From: Jonathan Parsons
Sent: 14 September 2011 10:10
To: 'lilleyarchitecture'
Cc: Katherine Rawlins; Eve Hearsey
Subject: P/51/11 Extension, alteration and new detached garage 7 Webb Close Pagham

Thank you for your useful comments on revising the application. I take on board your suggestions that regarding the deletion of the garage proposal, addition of the mono pitch roof over the extension and rearrangement of the balcony. I note that you suggest that the balcony will only extend out 1 metre from the rear and a greater distance on the side to the west which overlook your clients garden and a car parking and garage area.

West (side)

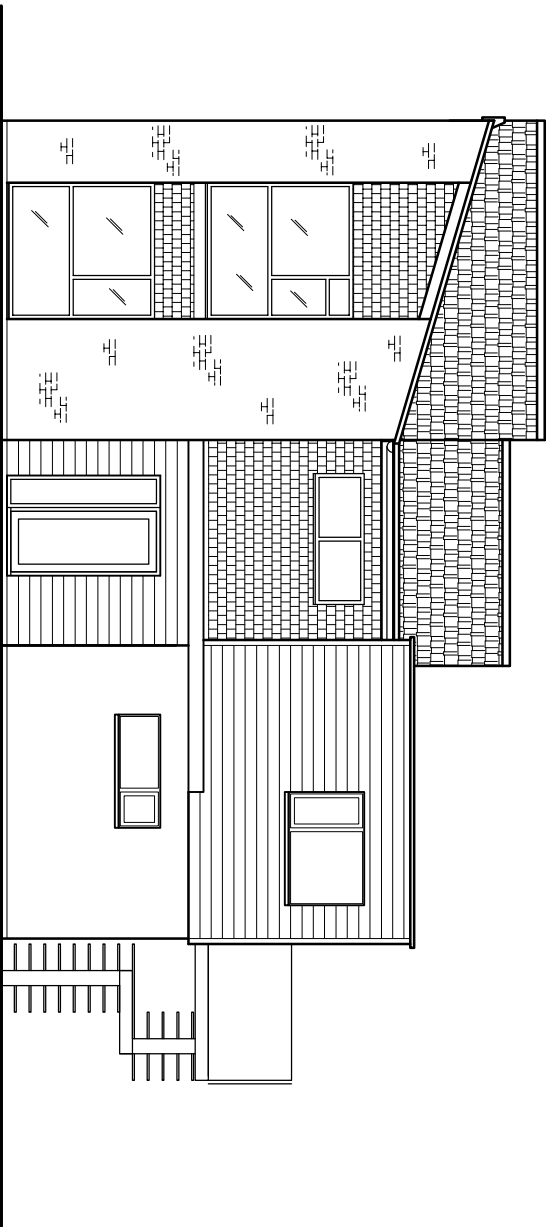
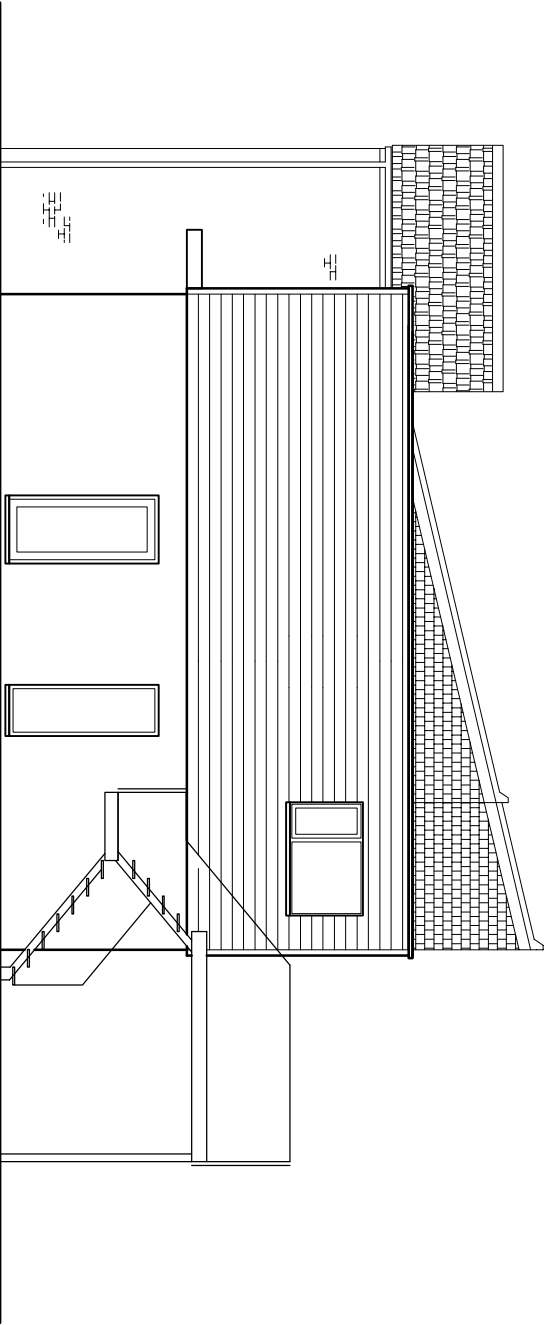
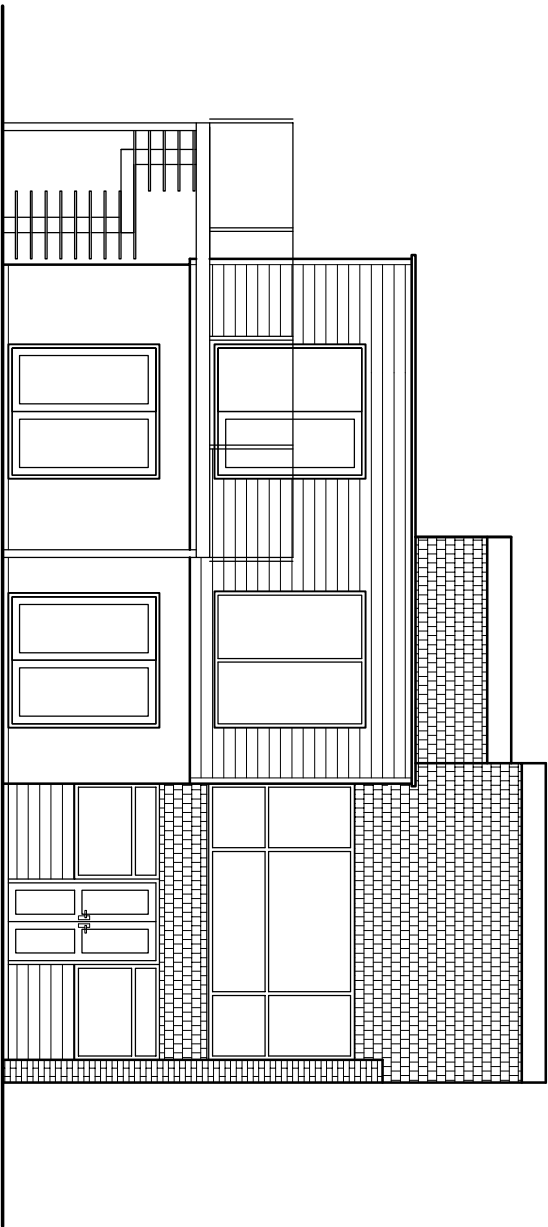
There is merit in what is proposed. However the proposal will be considerably be different to the submission which would require new advertising and notification of the Parish Council. In addition officers would still have to consider carefully the impact of any overlooking, even with the reduction in depth on the south elevation, on 17 given the change in levels and the orientation of mono pitch. Should the monopitch have it facing pitch roof sloping down to the western side or should it slope up from the front to the rear or should consist of two roof forms similar to the roof forms on eastern part of the existing building.
